**Consultation Response from KC,  
Trees**

**2024/92779 land at Providence Street, Earlsheaton, Dewsbury, WF12 8HZ**

**Outline application for residential development**

**Date Responded: 07/11/2024**

DRAWING:
ILLUSTRATIVE MASTERPLAN

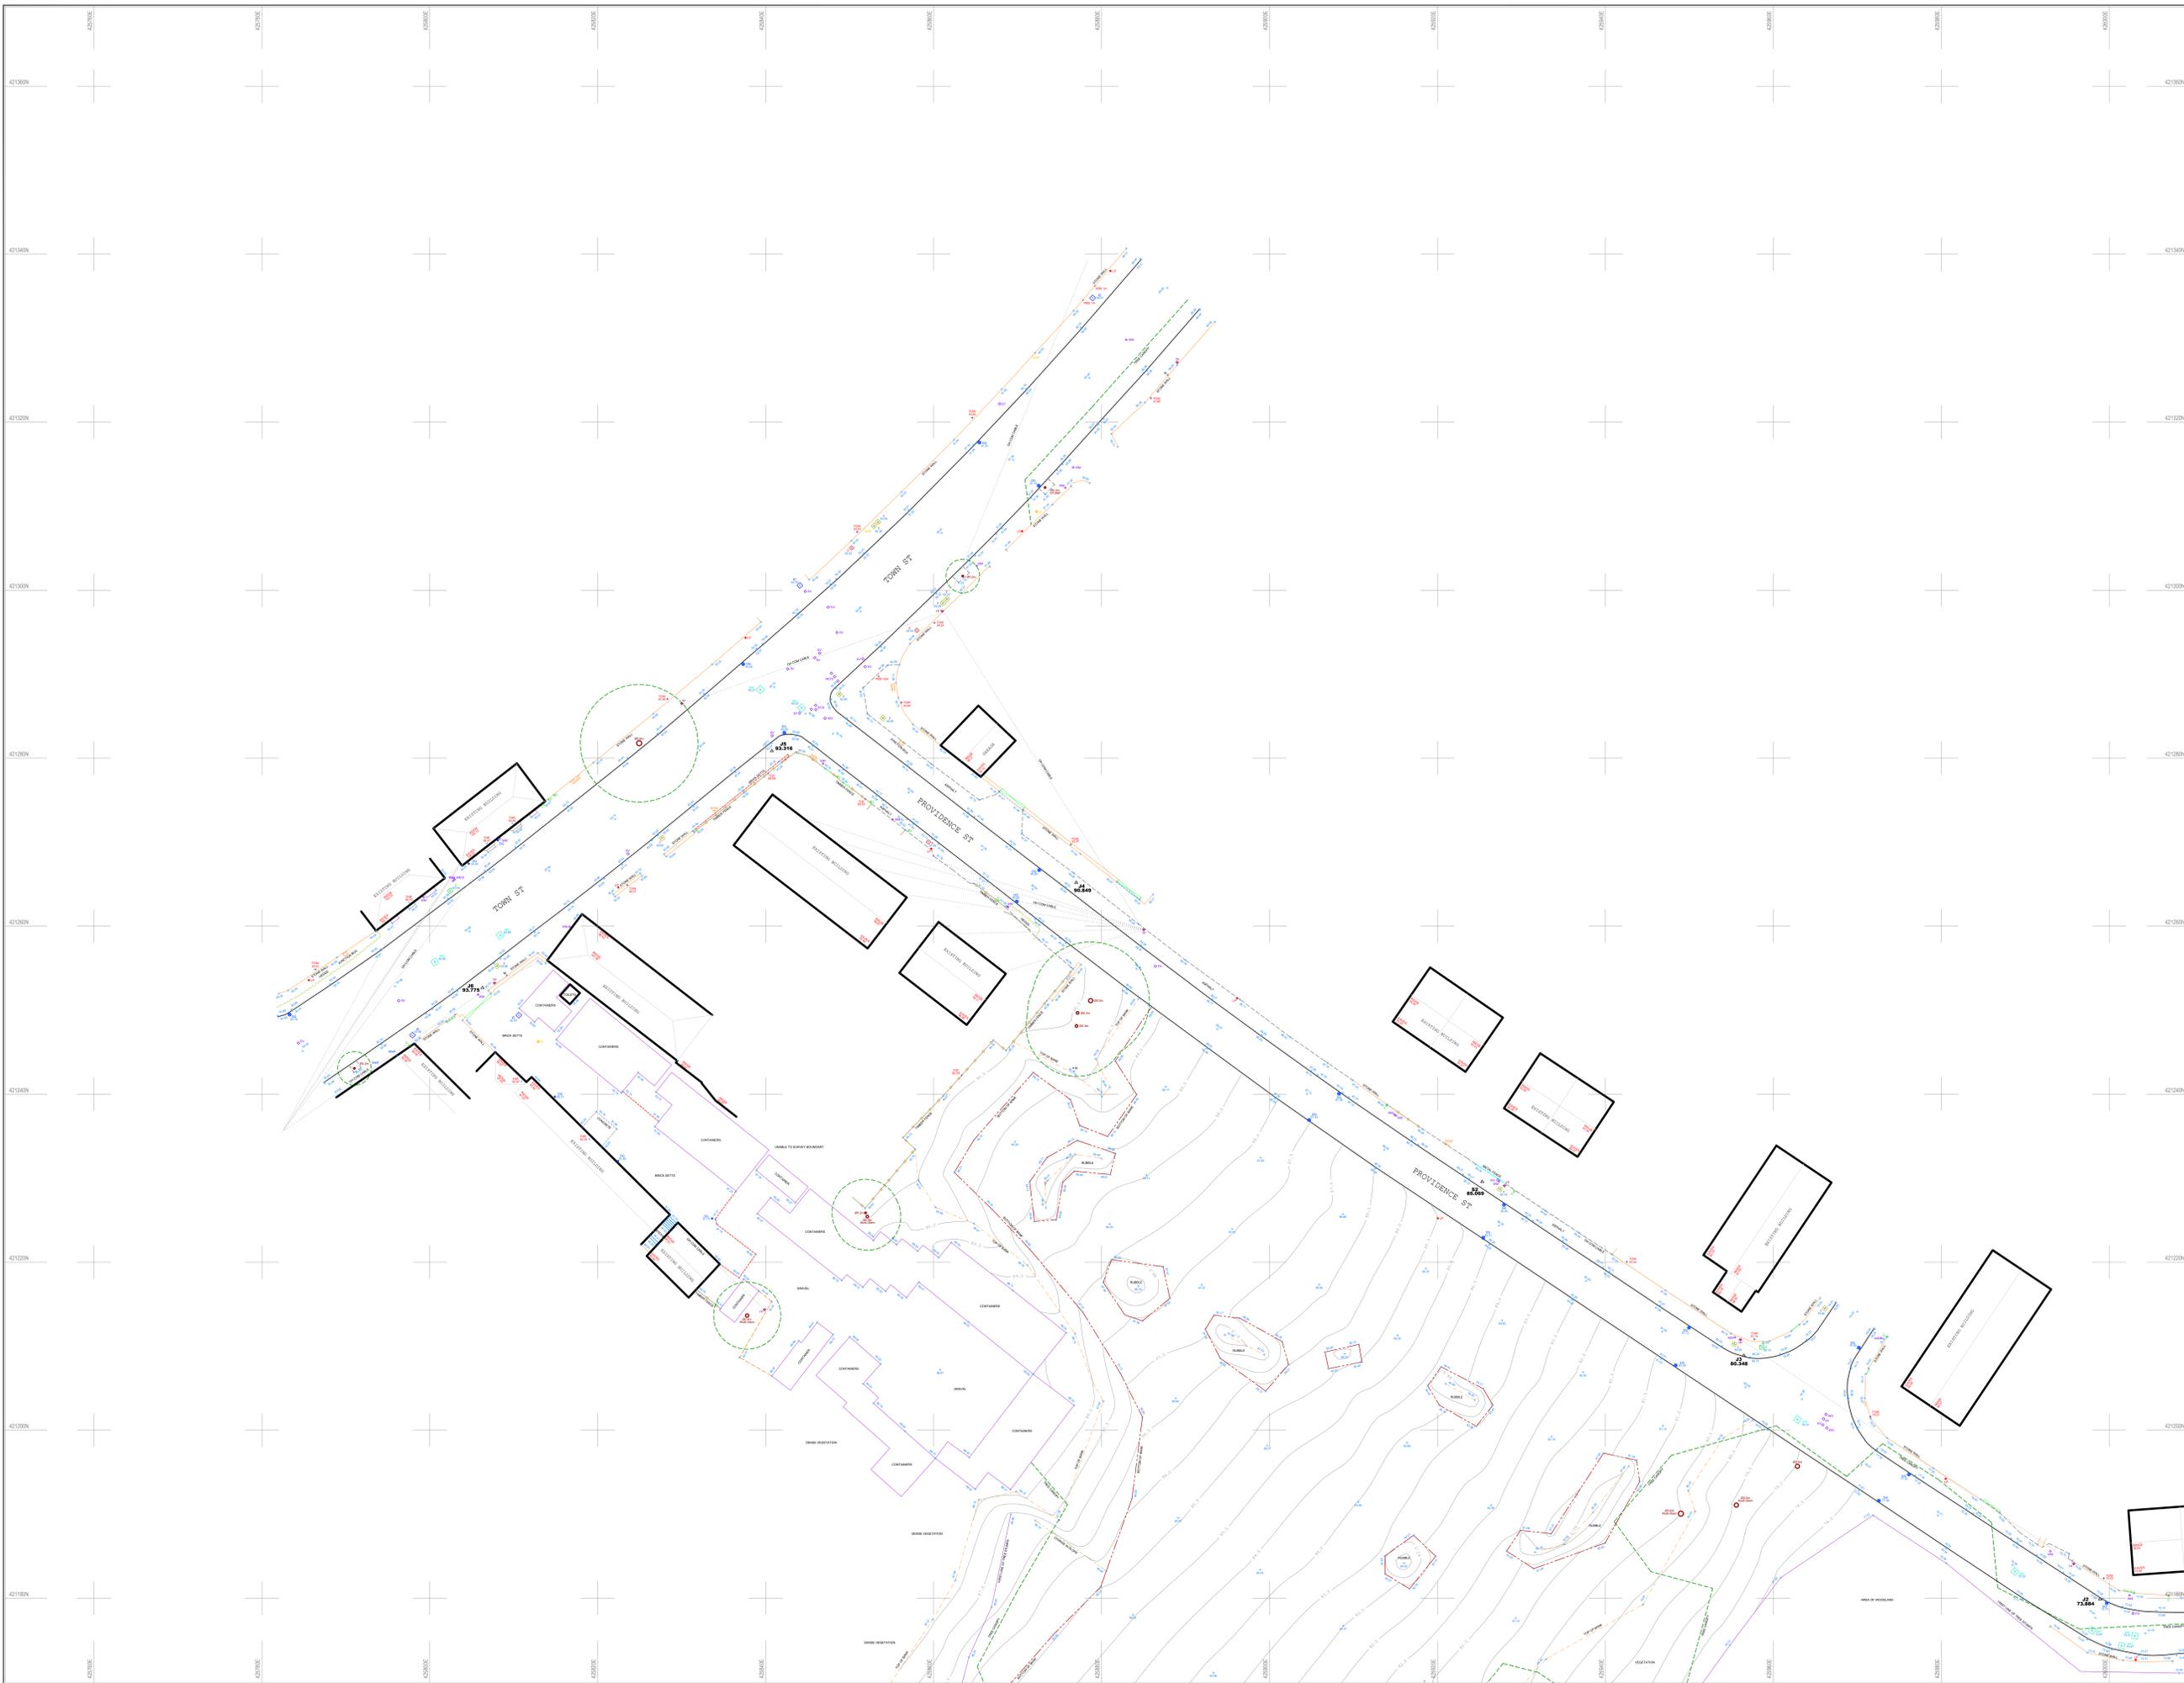
Any restocking notice is likely to dictate what potential space will be developable and therefore the submitted plans are likely to be void. Furthermore, the restocking may prompt a future TPO which again would change the comments/potential design layout.

There is an objection from a trees perspective for the reasons above and as the proposals have the possibility to conflict with a Restocking Notice and could then lead to an Enforcement Notice.

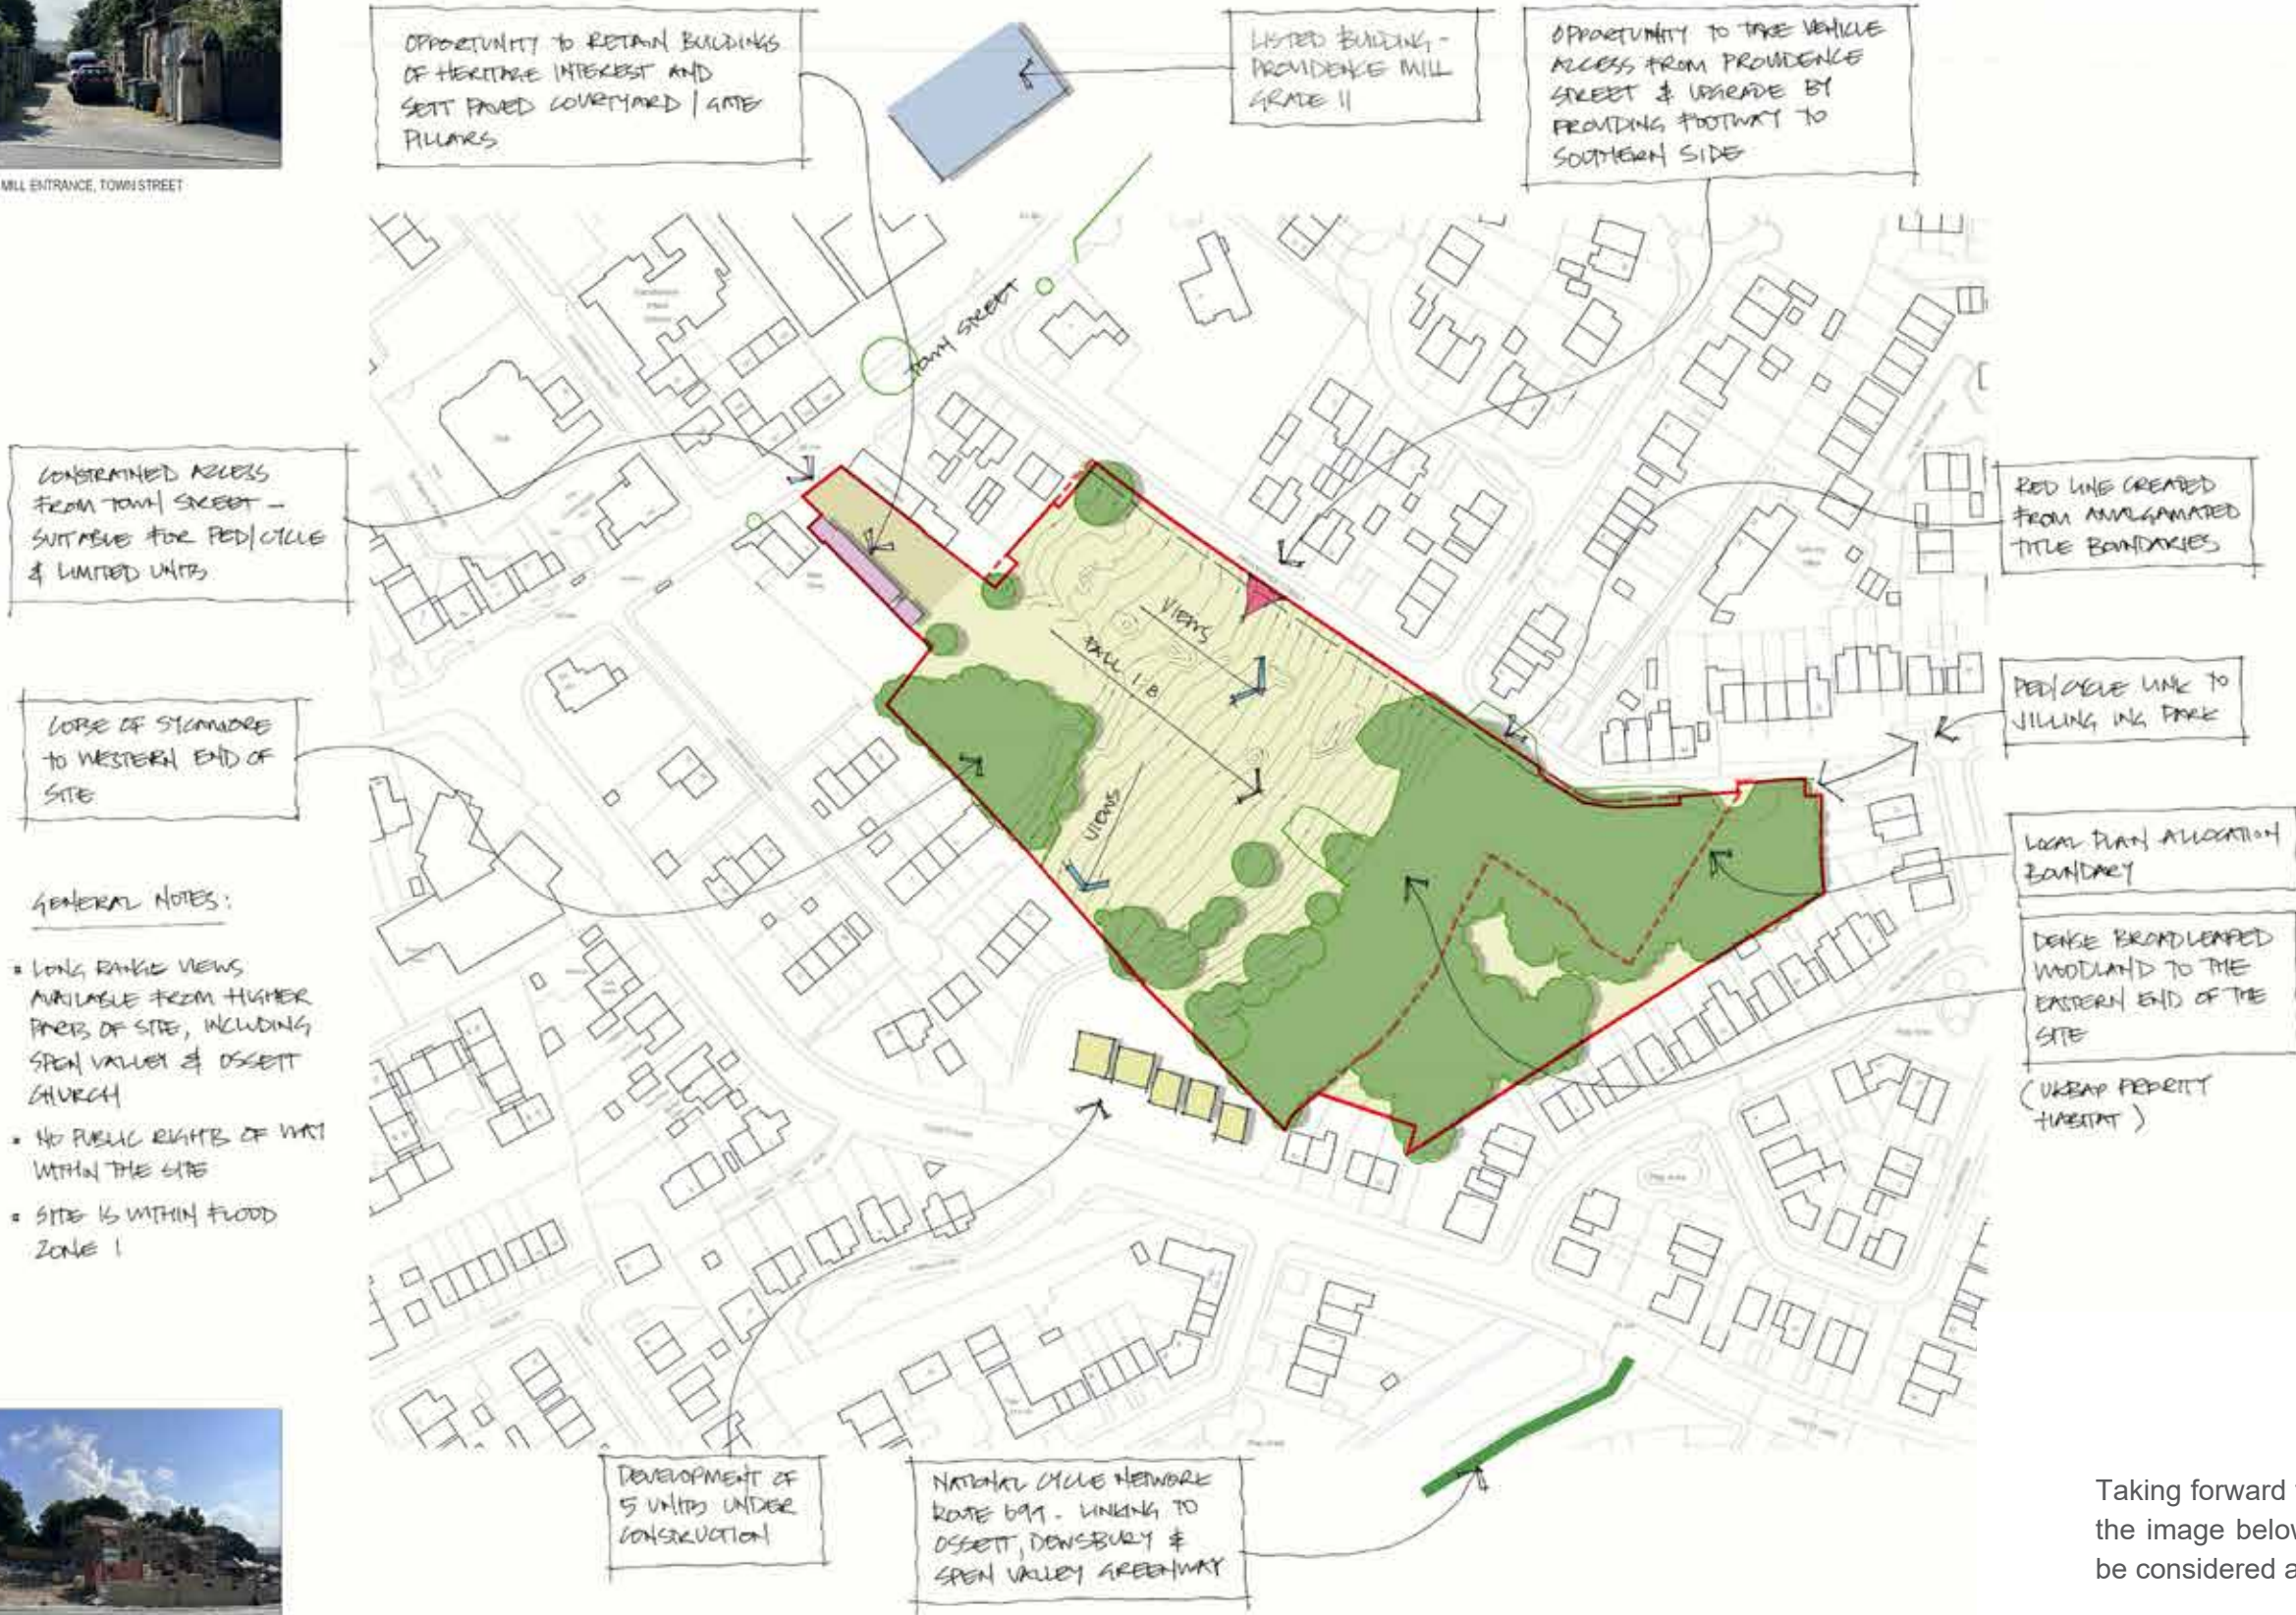
The submitted Tree Survey has awarded category B status to the majority of the trees still present on site which lead me to believe some of the felled trees may also have been category A or B trees and would therefore conflict with adopted Kirklees local plan policy 33 and 24 (i).
